LORSON RANCH EAST FILING NO. 1

STREET, STORM SEWER, AND POND CONSTRUCTION PLANS

LORSON RANCH EAST FIL. NO. 1
STREET/STORM SEWER
CONSTRUCTION PLANS

LORSON RANCH EAST FILING NO. 1
SIGNING/STRIPING PLAN
LORSON BOULEVARD

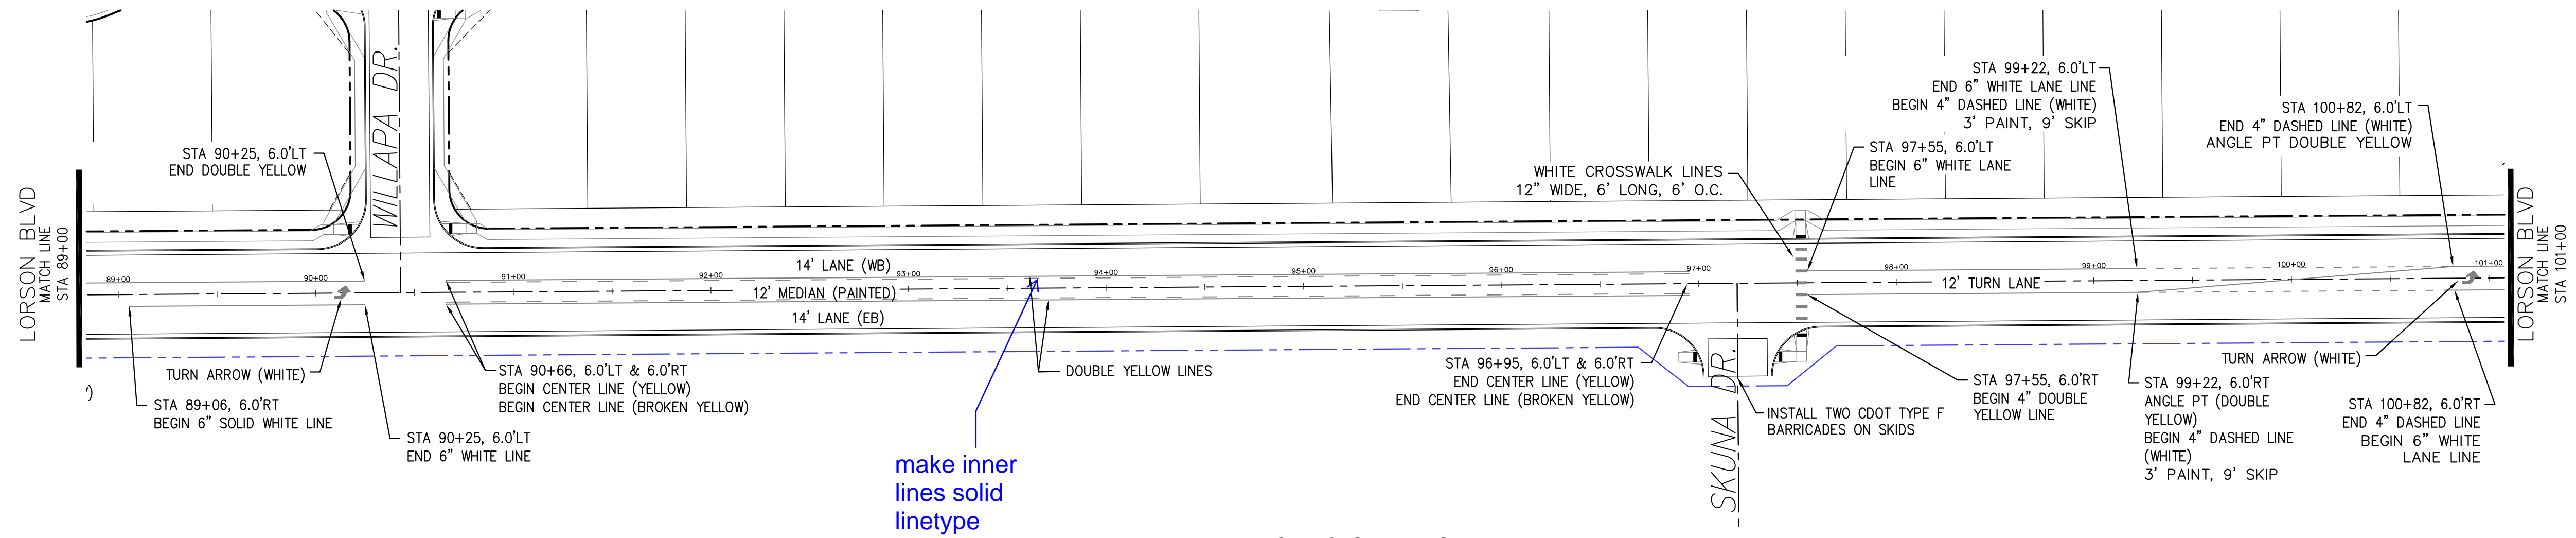
Adjust striping to show turn lanes, double yellow median striping.
